**Addendum No. 1**

RE: Contract # C204210

**Northampton County (R-2582A)**

US-158/NC-46 FROM I-95/NC-46 IN ROANOKE RAPIDS TO SR-1312  
(ST JOHN CHURCH ST).

**PORTABLE CONCRETE BARRIER
 AT
 TEMPORARY SHORING LOCATIONS**

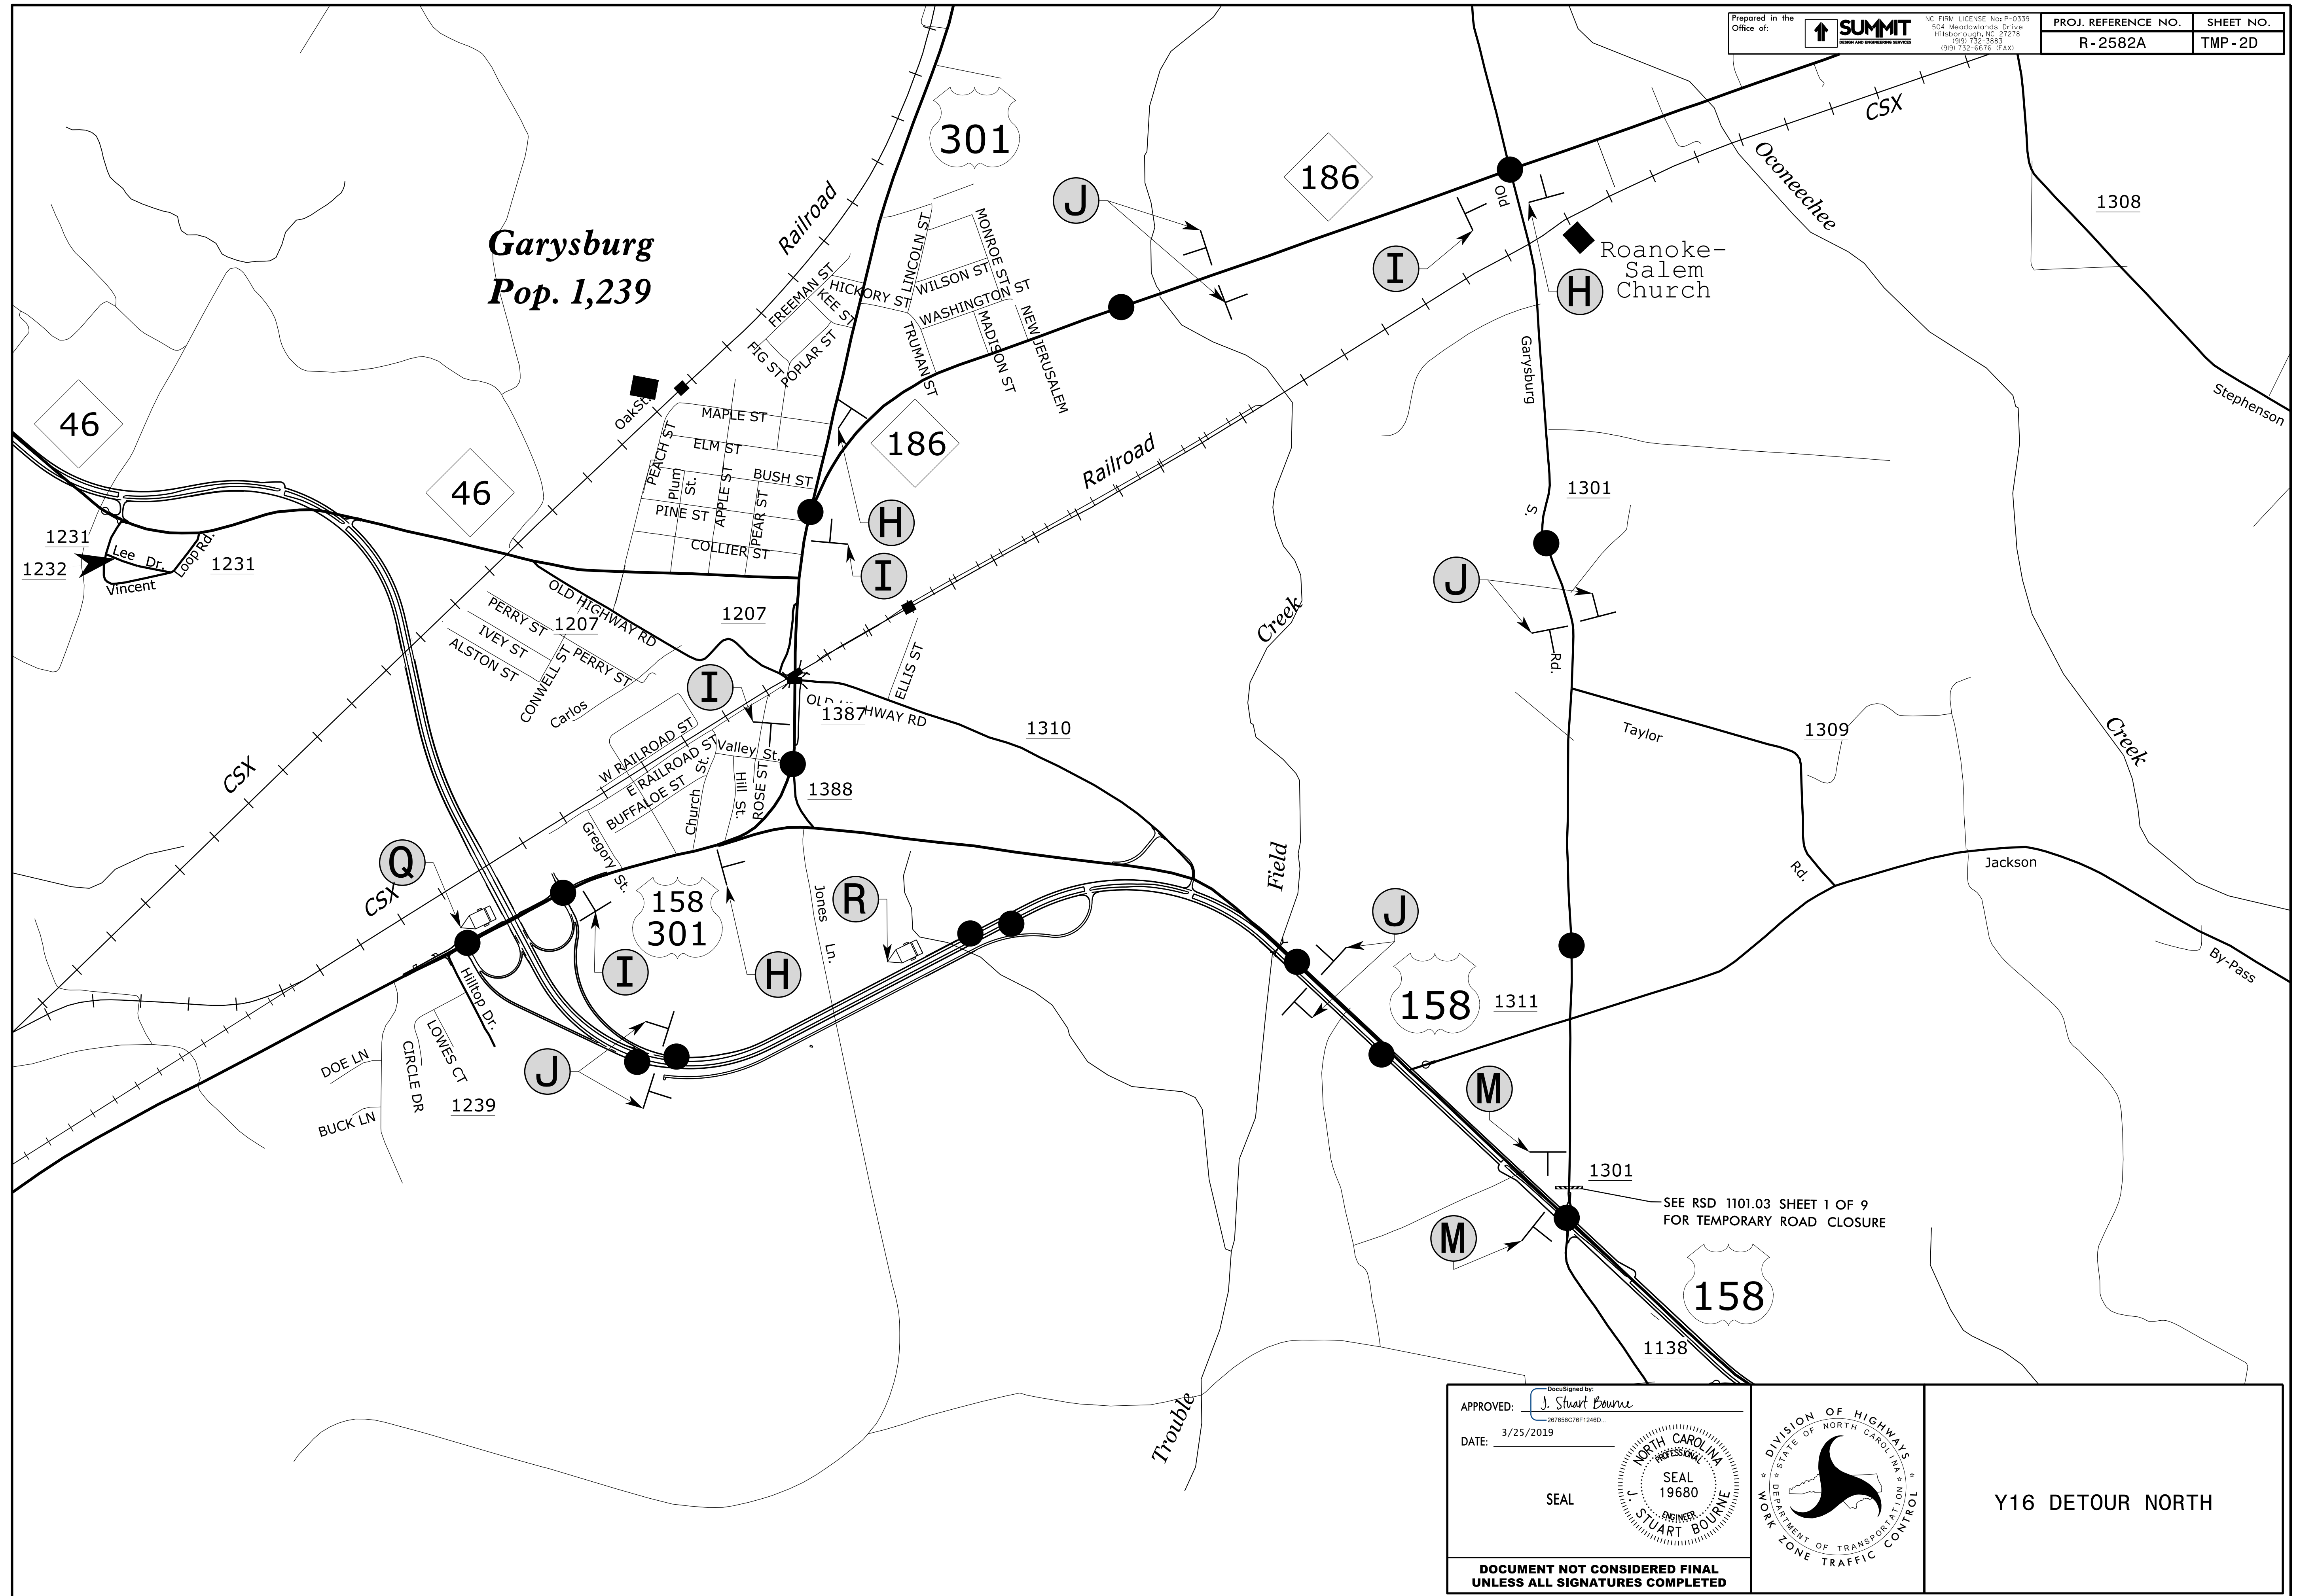
Sheet No.	Revision
TMP-2A	Revised Temporary Shoring No. 3 note.
UC-3C	Revised depth of bury notes. Removed references to CFPUA.
UC-3F	Revised to add 12" bypass piping and 12" valves to detail.

DESIGN TEMPORARY SHORING FROM STATION -L- 286+40±, 12.0 FT. LEFT, TO STATION -L- 286+75±, 12.0 FT. LEFT, FOR THE FOLLOWING ASSUMED SOIL PARAMETERS AND GROUNDWATER ELEVATION:

UNIT WEIGHT ( $\gamma$ ) = 120 LB/CF  
 FRICTION ANGLE ( $\phi$ ) = 30 DEGREES  
 COHESION (c) = 0 LB/SF  
 GROUNDWATER ELEVATION = 69.5 FT ±

DO NOT USE A TEMPORARY WALL FOR TEMPORARY SHORING FROM STATION -L- 286+40±, 12.0 FT. LEFT, TO STATION -L- 286+75±, 12.0 FT. LEFT.

AT THE CONTRACTOR'S OPTION, USE STANDARD TEMPORARY SHORING FOR TEMPORARY SHORING FROM STATION -L- 286+40±, 12.0 FT. LEFT, TO STATION -L- 286+75±, 12.0 FT. LEFT. SEE STANDARD DETAIL NO. 1801.01 FOR STANDARD TEMPORARY SHORING.
